Address: 46 Station Road Huddersfield HD80AD

Application number: 2025/91627	
What is the application for?:	Erection of two storey extension to side and front, balcony to rear and associat
Address of the site or building:	42A, Station Road, Fenay Bridge, Huddersfield, HD8 0AD
Postcode:	HD8 0AD

Ref 2025/62/91627

Proposed Elevations

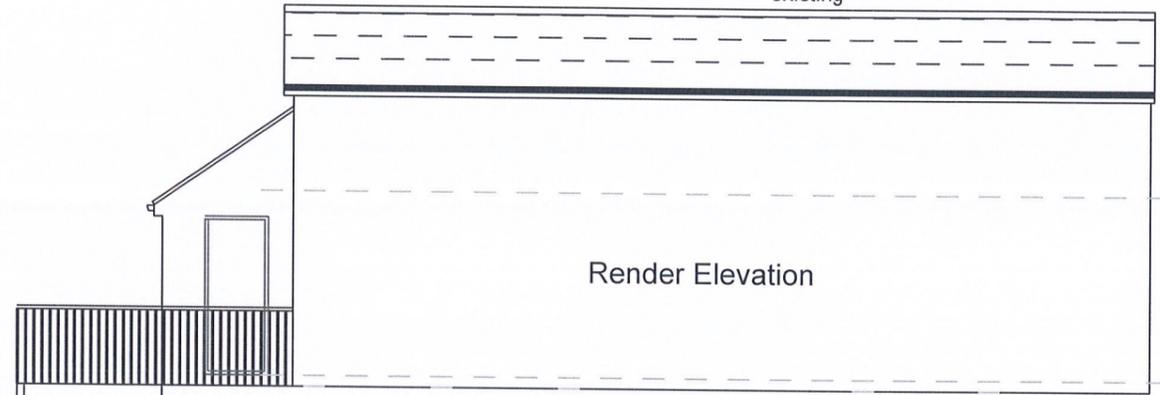
The scale of the proposed extension is not subservient to the existing property. It is overbearing and will impact my property in respect of light especially at different times of the year when it is so important.

The proposed extension given its position will directly impact negatively the privacy and light of my property and its amenities. It will overlook my property and garden area and it will also be seen from a number of rooms from my property and therefore has a negative impact on both privacy and light to my property

It is completely inaccurate for the supporting statement by AK planning to state that the extension is hidden well away from public view including neighbours. My own properties and a number of properties would see this imposing proposed development and it would change the character of the area considerably. Whilst it would afford the current owners outlook in a positive way it is to the detriment of others.

Site Plan & Roof Plan		
Fenay Bridge		
HD8 0AD		
Date	May 2025	Dwg no 05
Scale	A3 - 1:200	
Dwn By	-----

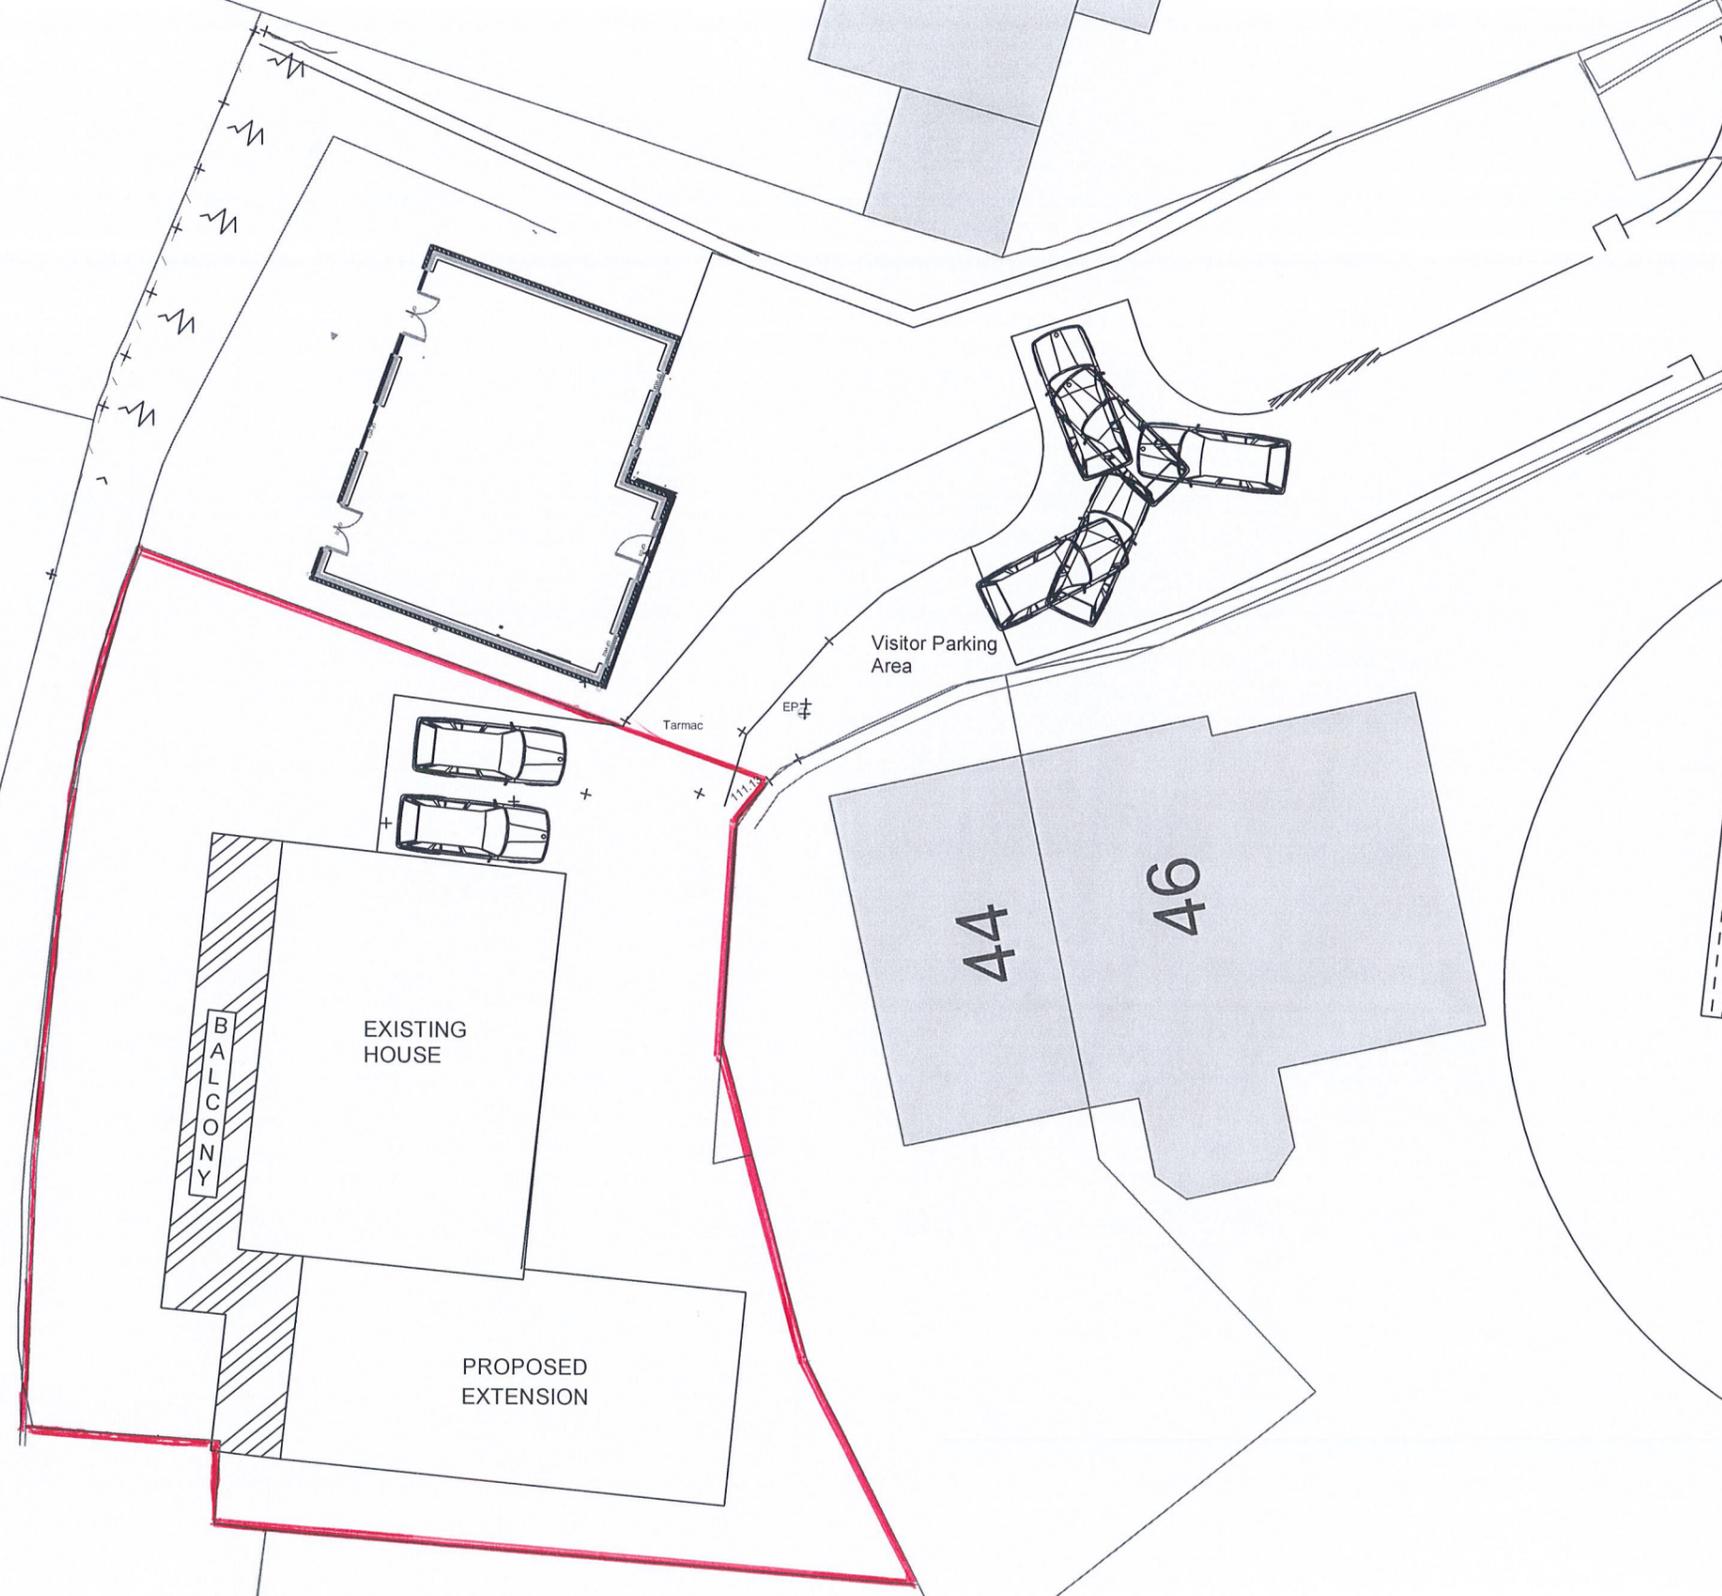
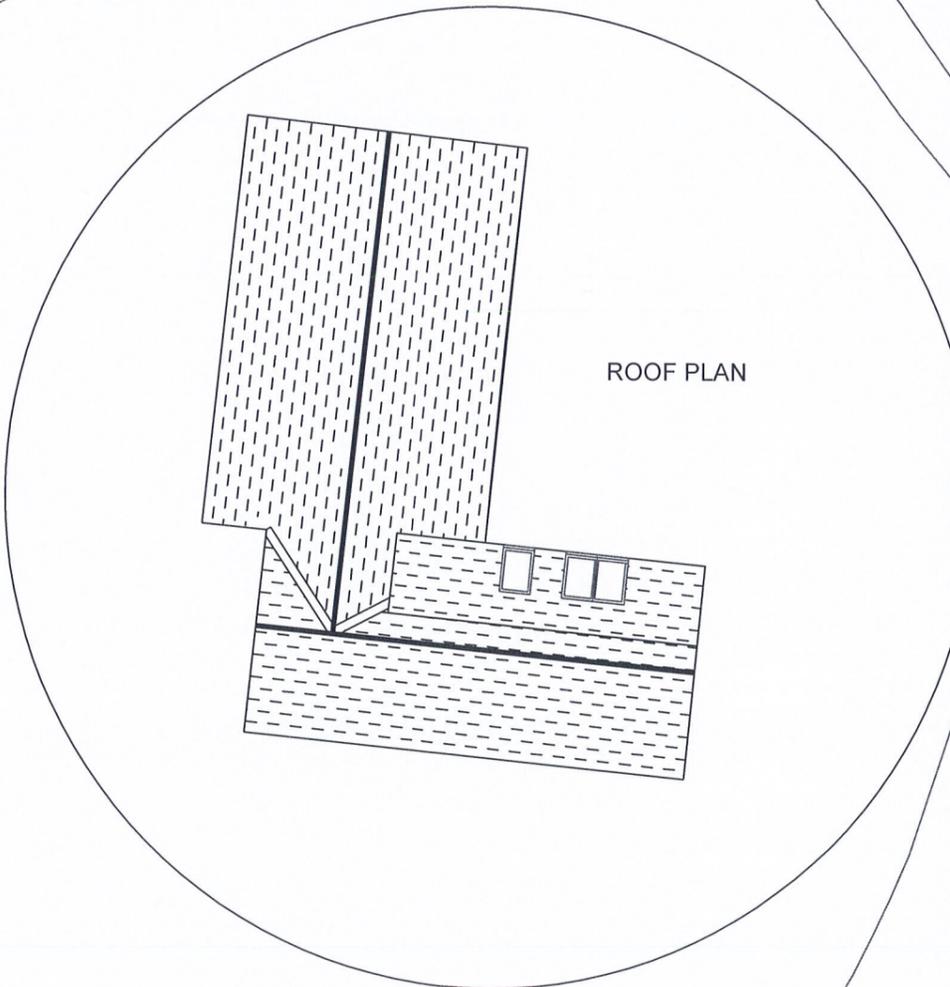
I consider this proposed extension to be the overdevelopment of an area particularly considering the ongoing build of a 4 bedroomed property within the grounds of 42a and this extension would mean further garden grabbing within this area. Leaving very little land around the property is out of character of neighbouring properties. This is clearly an additional build. This will change the character of the area and is not in keeping with properties surrounding this proposed development.

The proposed extension also has an impact on residential amenity for any future owner of 42a, due to its proximity to neighbouring properties and lack of surrounding garden space.

This proposal will also interfere with current sewage pipe work from several properties.
